# SF17023-V2b-CDs.pdf Markup Summary

dsdrice (8)

FINAL
SITE GRADING
TYPICAL ROADWAY SECTIONS

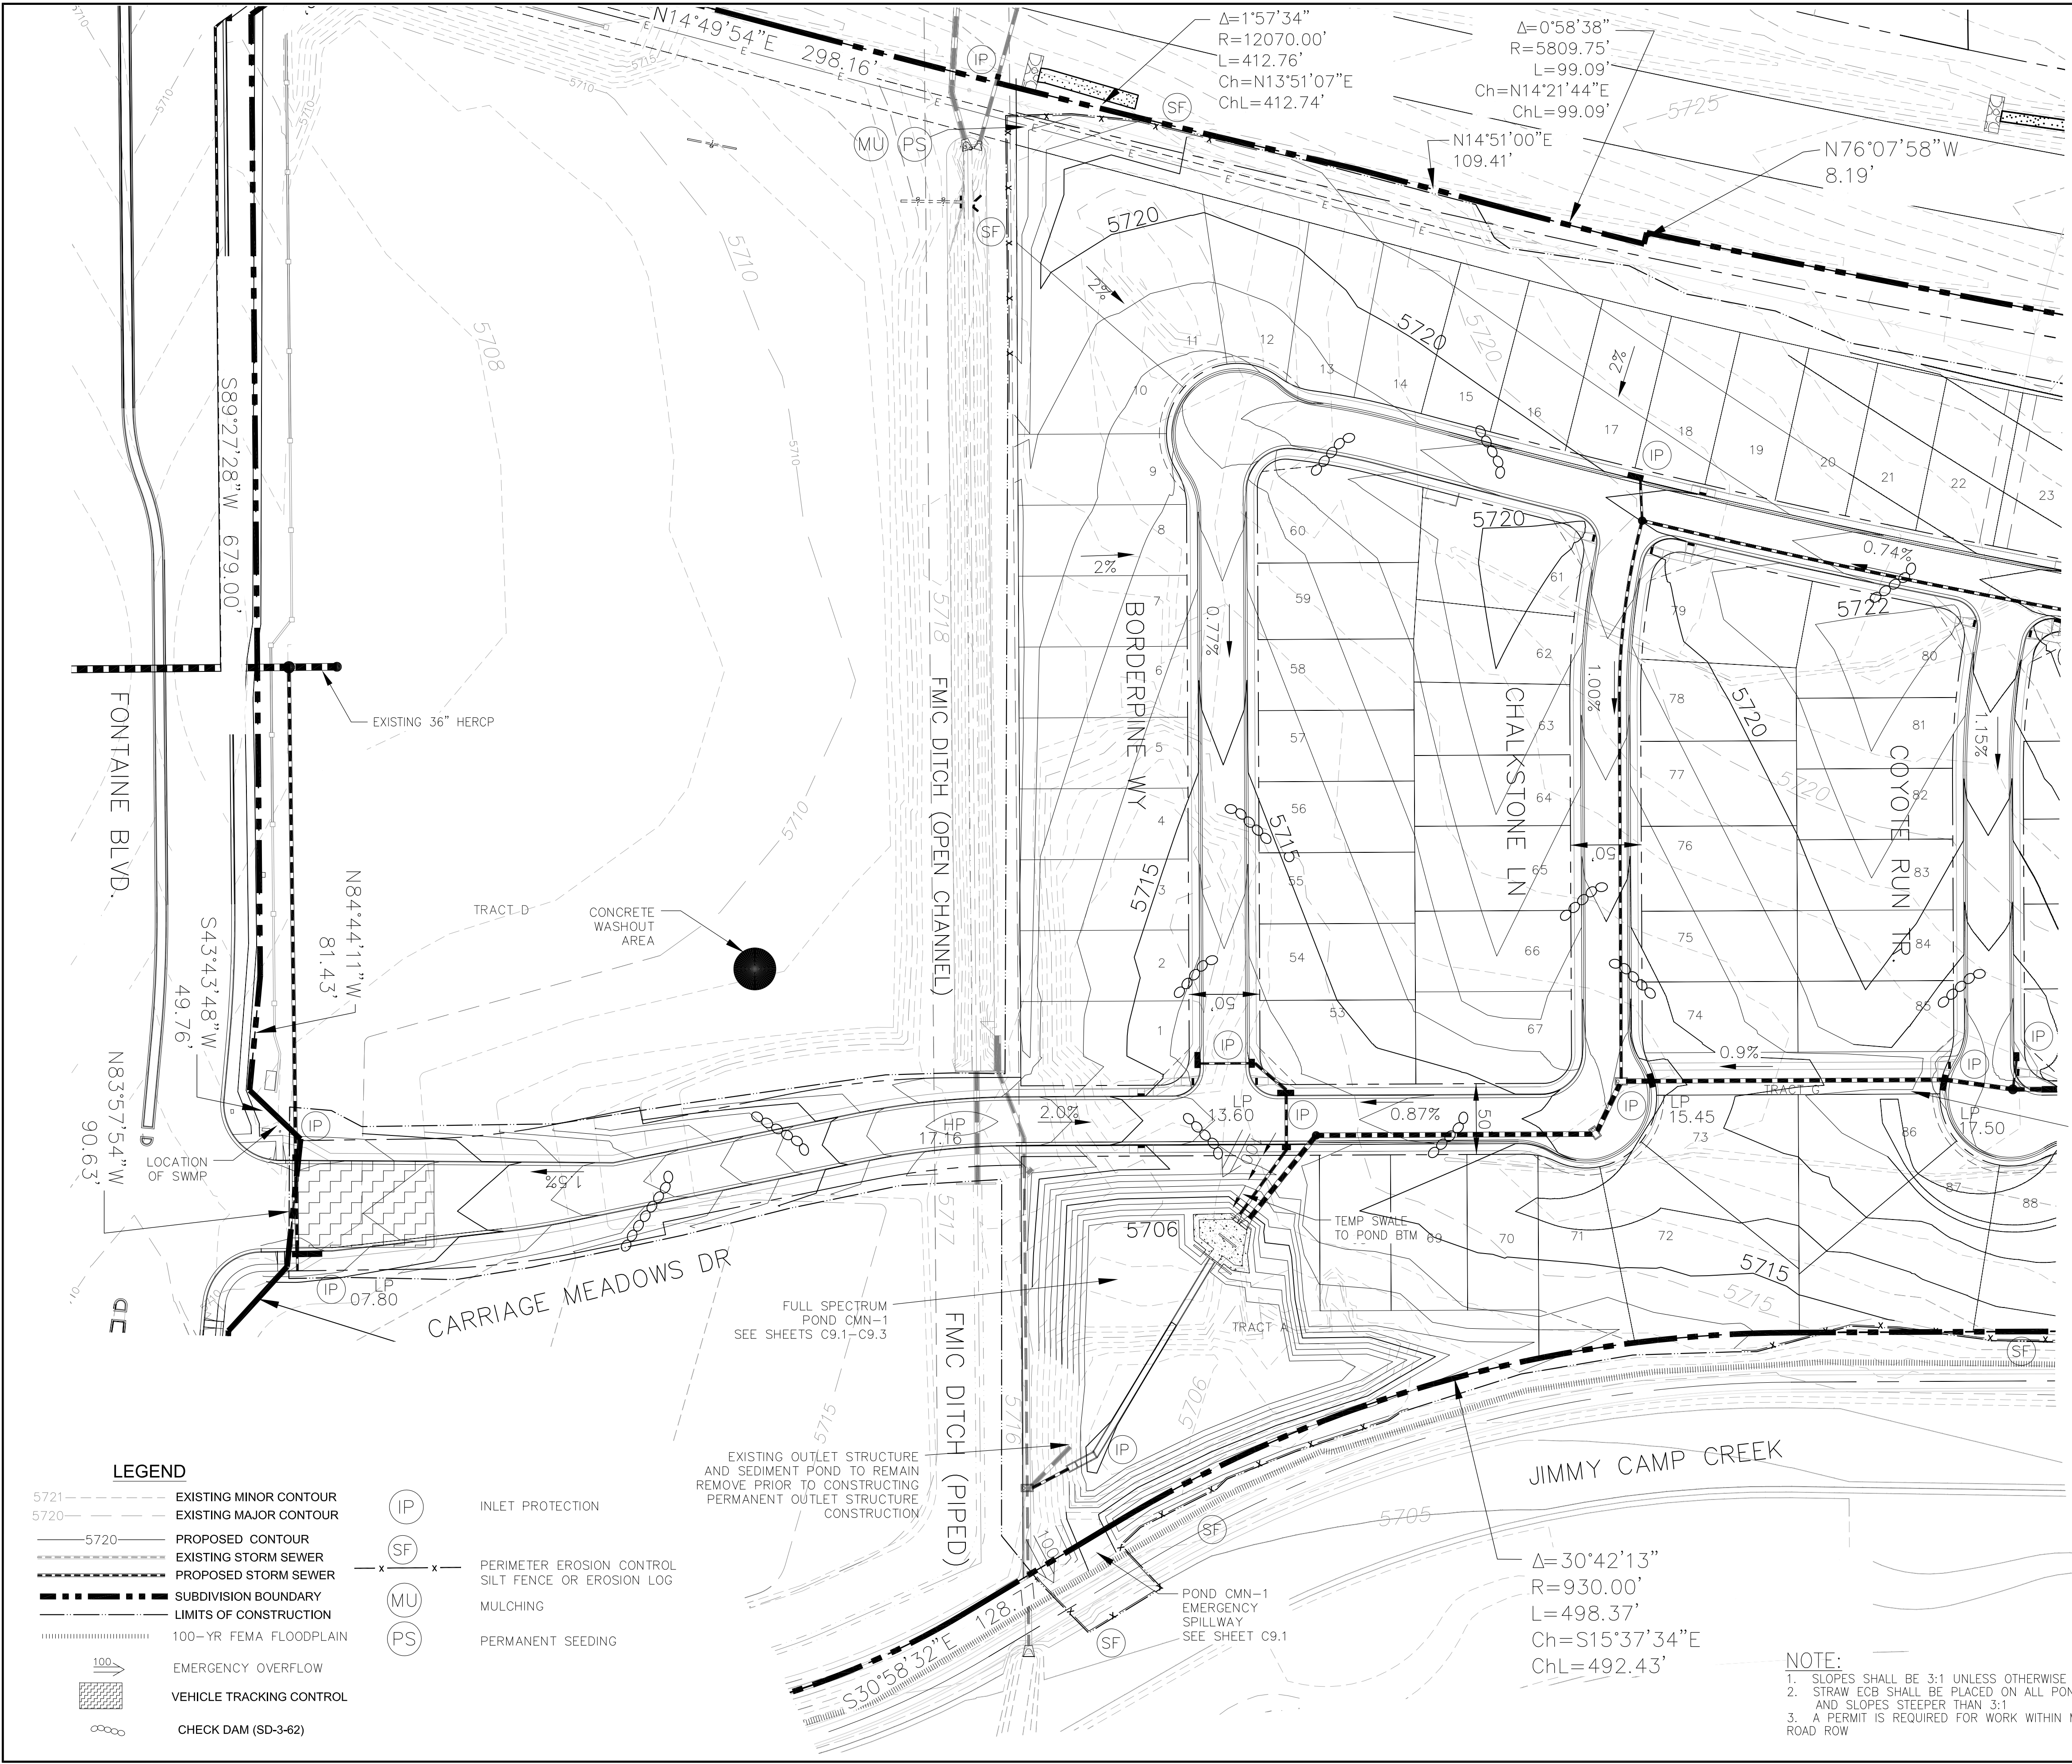
ROW line is missing/moved.

Provide complete details including connections, elevation plans, rebar, etc., or add note that shop drawings will be required prior to construction.
